**WELWYN HATFIELD BOROUGH COUNCIL
EXECUTIVE DIRECTOR - PLANNING, PUBLIC PROTECTION AND GOVERNANCE**

DELEGATED APPLICATION

Application No: 6/2018/0371/HOUSE
Location: Stocks Lysley Place Brookmans Park Hatfield AL9 6NZ
Proposal: Erection of single storey side extension following demolition of double garage
Officer: Ms Lucy Hale

Recommendation: Granted

CLIENT Mr & Mrs Cumberland
LOCATION/PROJECT Stocks, Lysley Place, Brooksmans Park, Hatfield, Hertfordshire, AL9 6NZ
TITLE OF DRAWING Existing & Proposed Blockplan

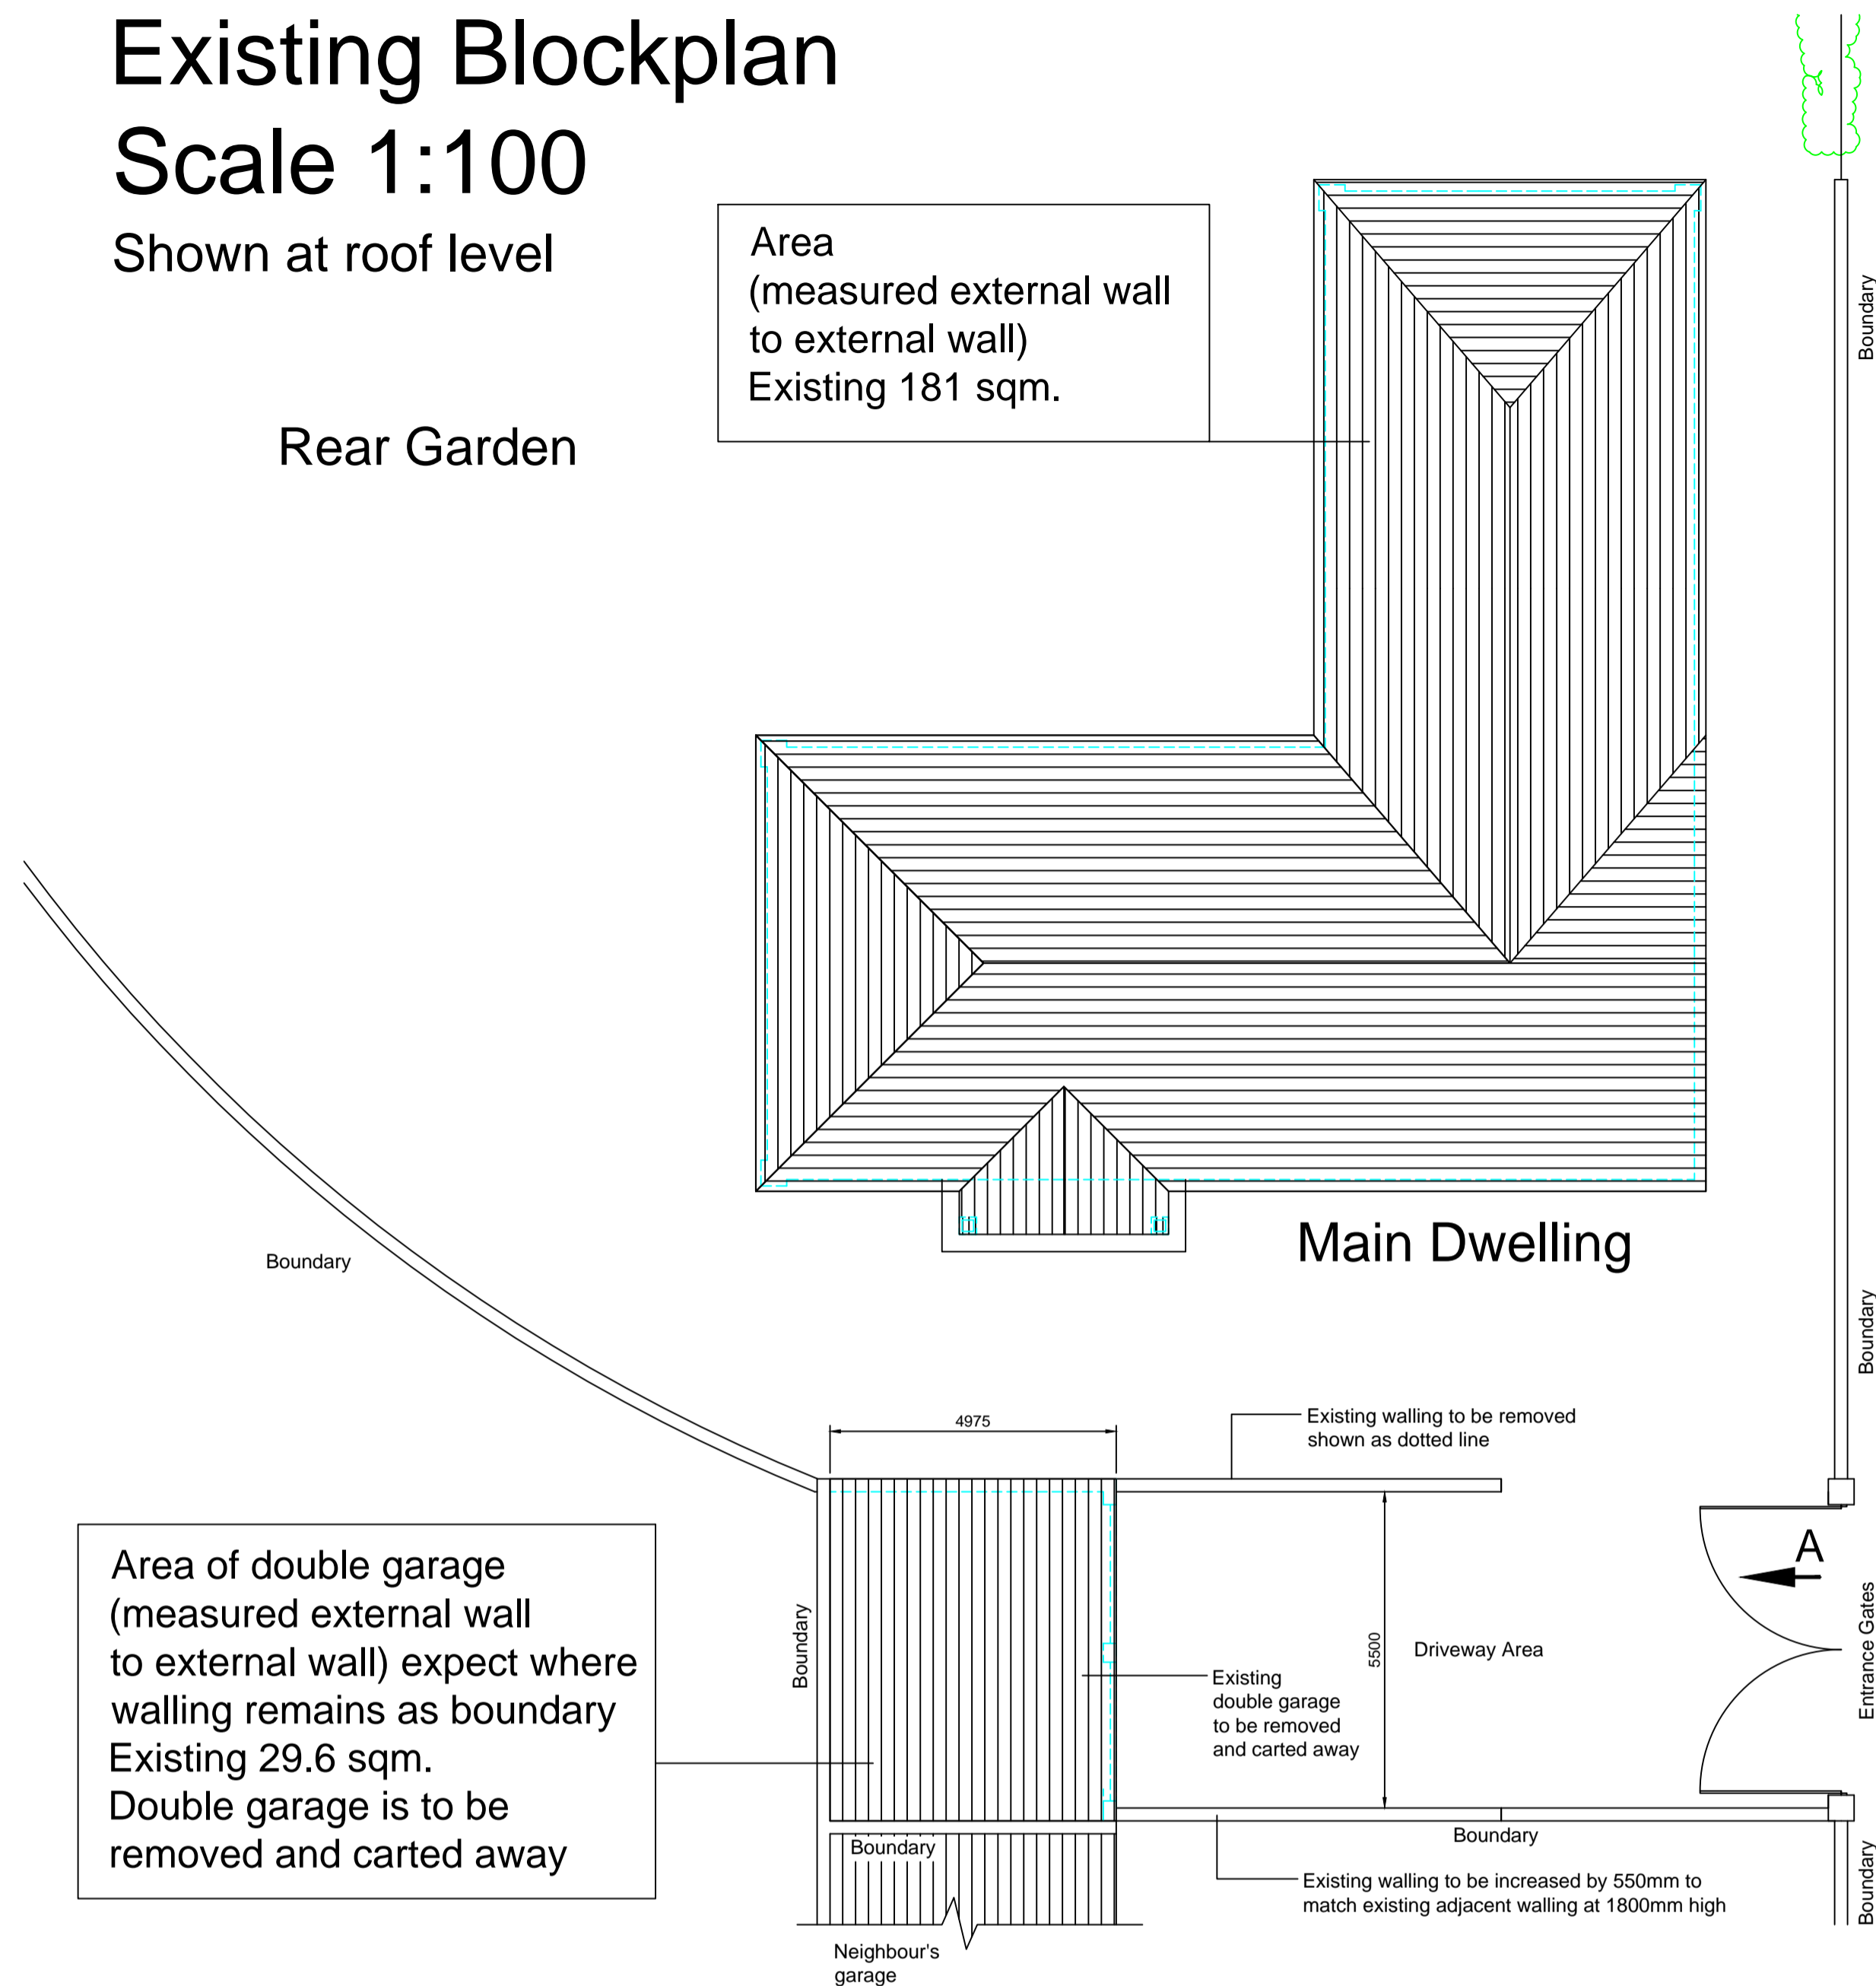
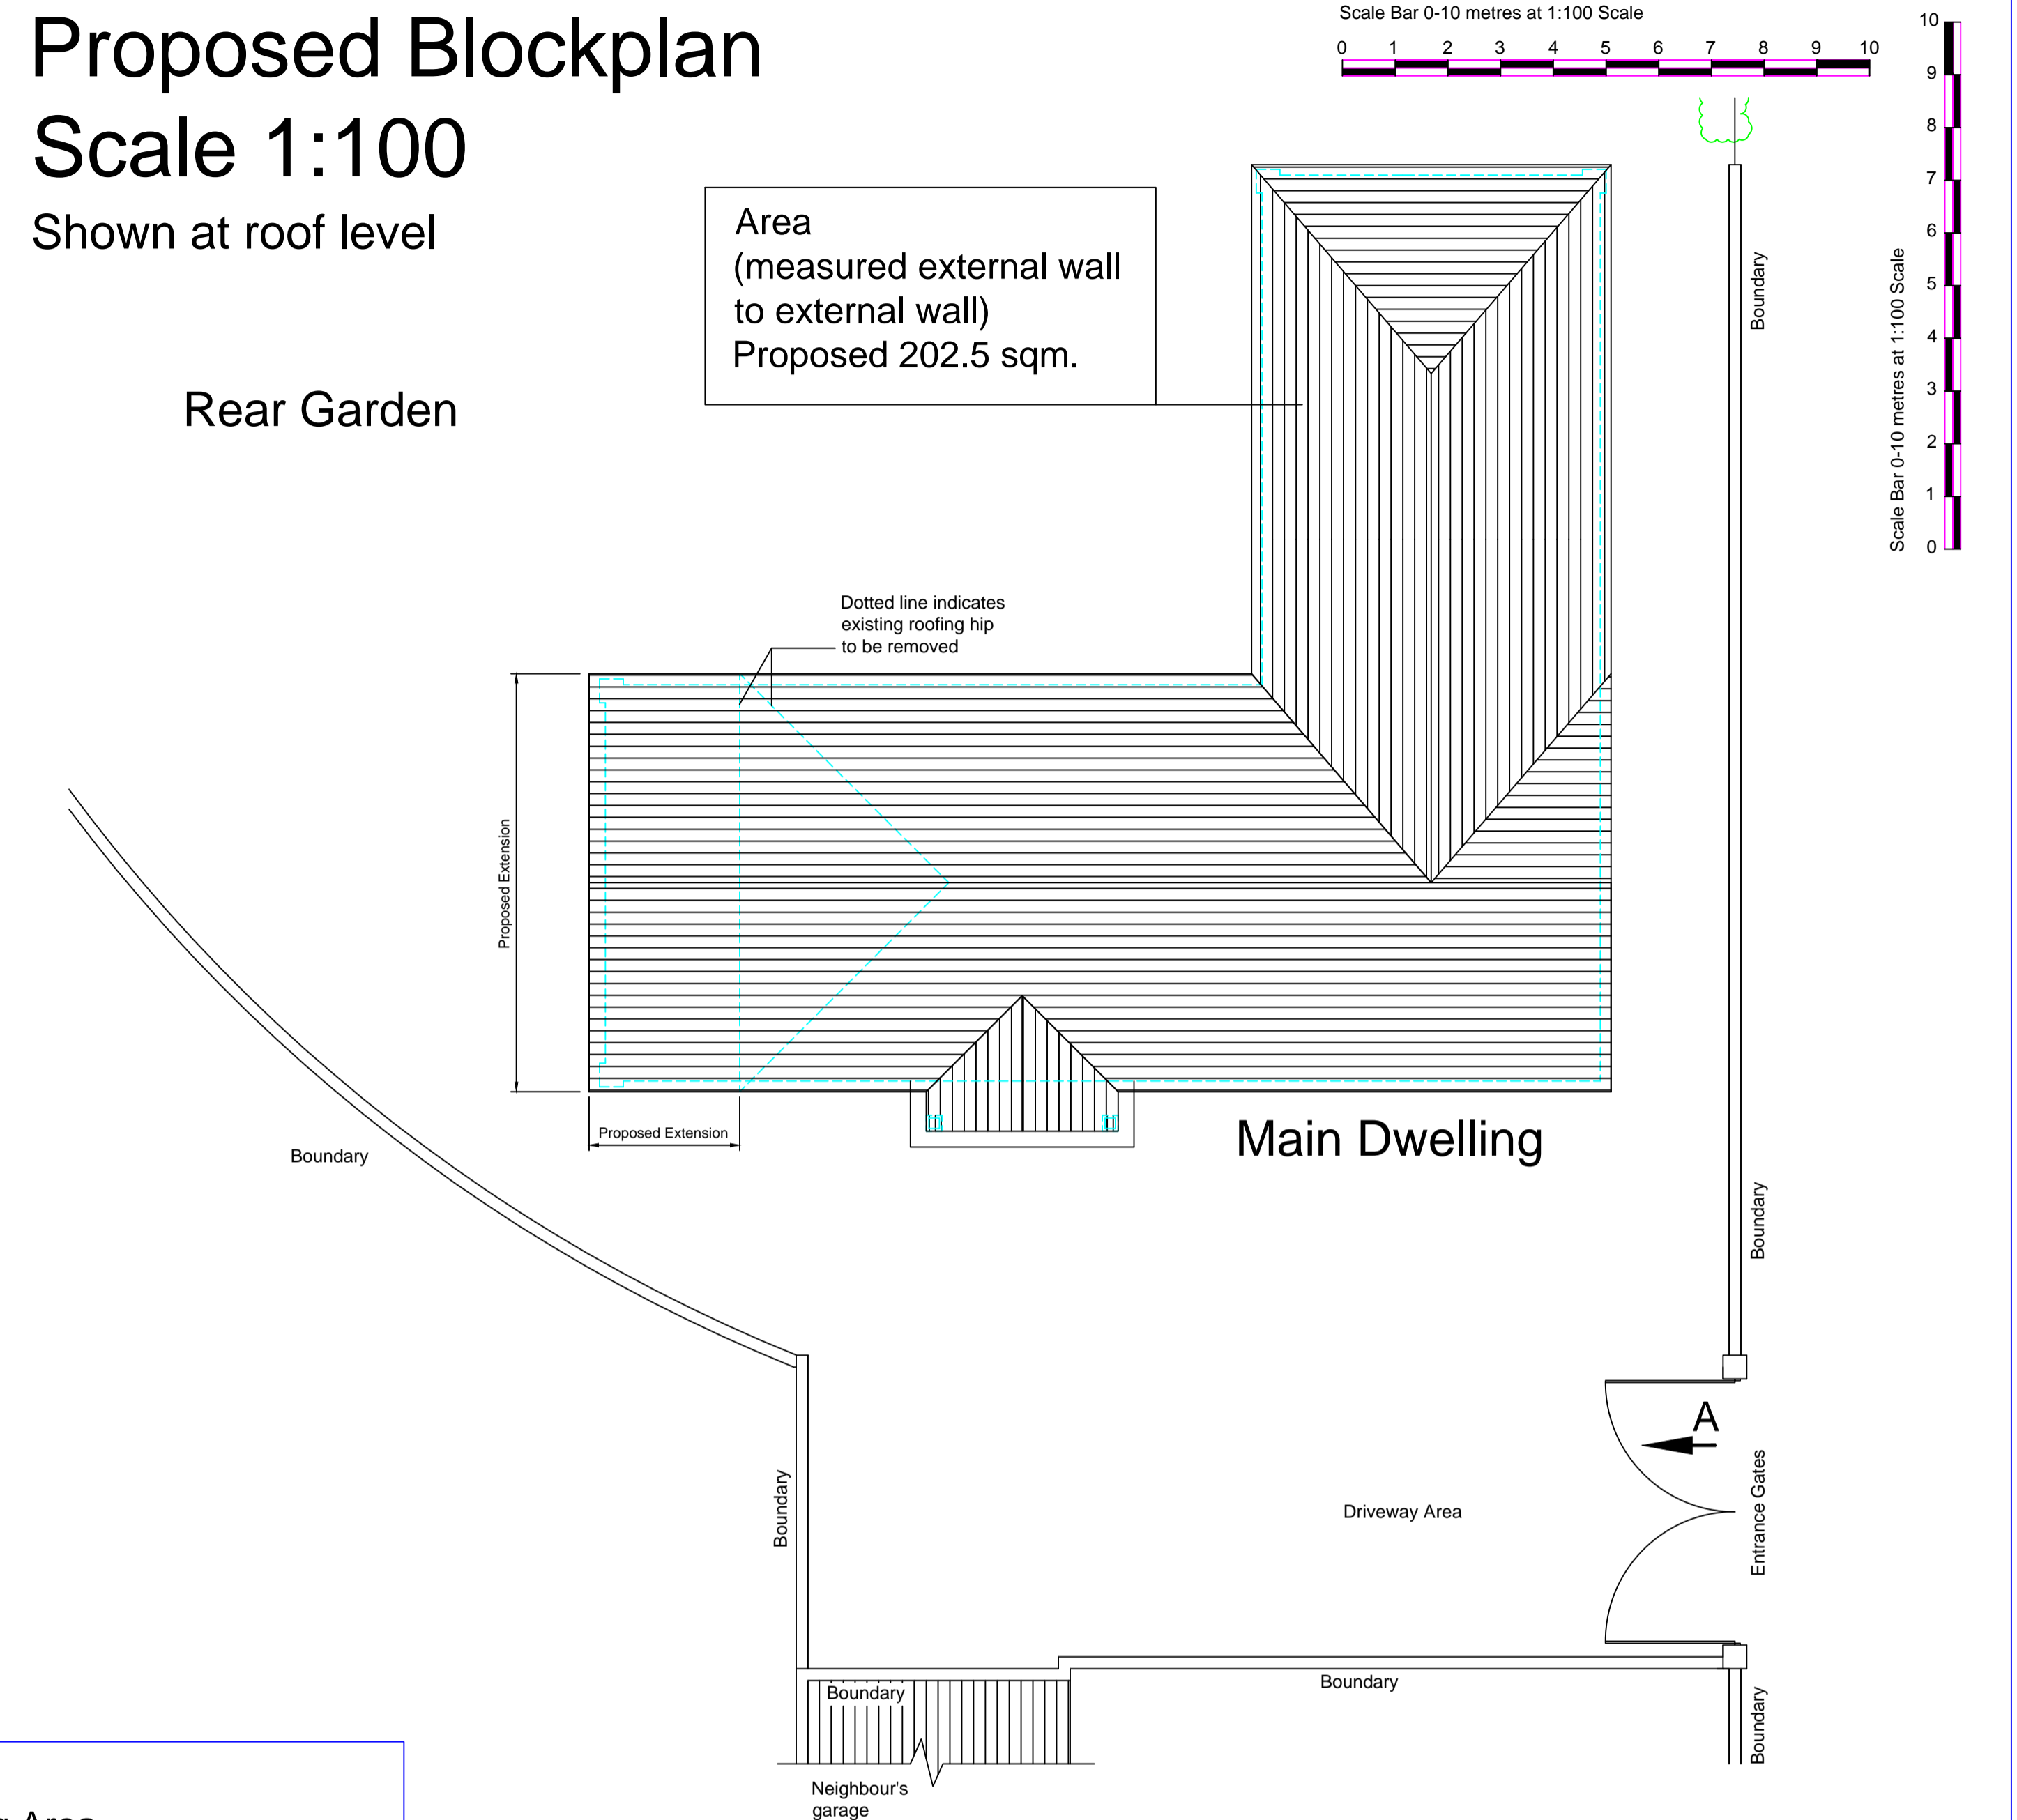
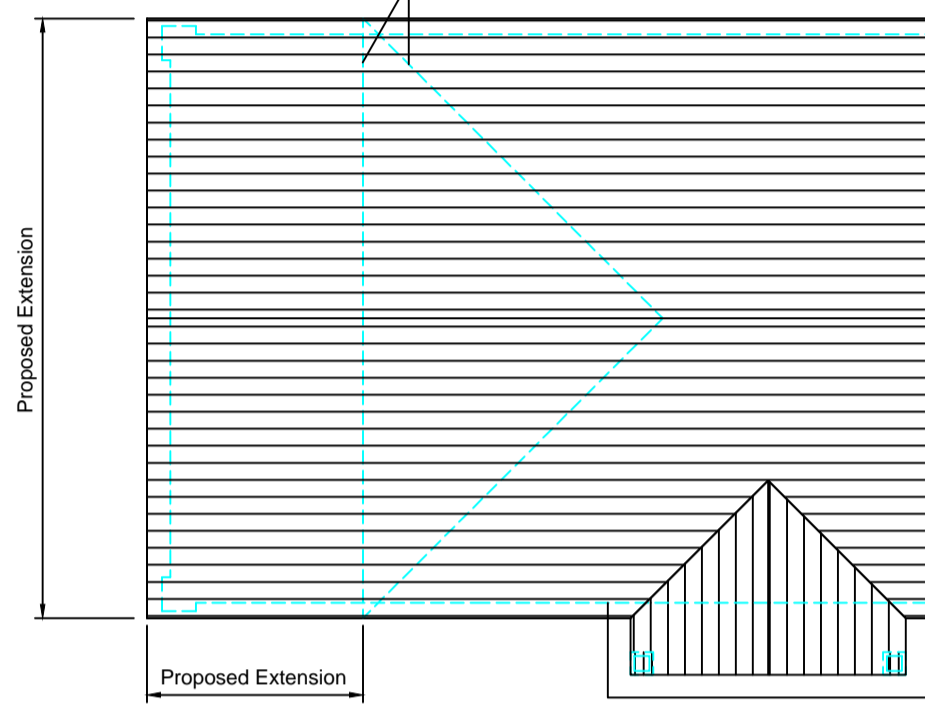
<p>harm, is clearly outweighed by other considerations.</p> <p>The applicant has submitted supporting information outlining that the garage is to be demolished, which would remove some of the built development within the plot. This reduction would be an attempt to offset the additional bulk and massing of the proposal.</p> <p>The garage has not been taken into account in the calculations of the dwellings floor area and it does not form a habitable area. However, it does add bulk and mass within the plot and the Draft Local Plan 2016, Policy SADM 34 outlines the volume or footprint of existing buildings to be demolished within the site may be offset against increases in volume and footprint, taking into account the size, permanence, design and proximity to the building to be extended. Furthermore, it outlines that buildings within 5 metres of the main dwelling will be treated as an extension to the main dwelling.</p> <p>The existing detached garage has a floor space of approximately 29.6 sqm and whilst ancillary, is positioned approximately 4.5 metres away from the dwelling. The garage measures approximately 5.5 metres in width by 4.9 metres in depth. When considering the quantitative calculations the existing garage has a floor space of 29.6 sqm compared to the proposed extension of 22 sqm, which equates to a reduced floor space than existing. It is also important to consider a qualitative comparison. The garage is located to the front of the dwelling and is attached to the neighbouring garage. It is considered that the existing garage contributes to the spread of the development within the plot and an impact on openness as a result of its size, roof form and siting. Whilst it is noted that the proposed extension would feature a gable end, which would add bulk to the appearance of the dwelling, the extension has been designed to relate to the form and ridge height of the existing dwelling. The location to the side of the dwelling confines the spread of the development and the removal of the garage would contribute to an increase in openness between the application dwelling and the adjoining site.</p> <p>On balance, it is considered that the impact of the proposed extension would be sufficiently mitigated by the removal of garage. The circumstances presented would outweigh the harm to the Green Belt by way of appropriateness and therefore 'very special circumstances' exist.</p>

1. Prior to construction of the extension hereby permitted, the existing double garage to the western side of the site shall be demolished and all the materials arising from such demolition shall be completely removed from the site.
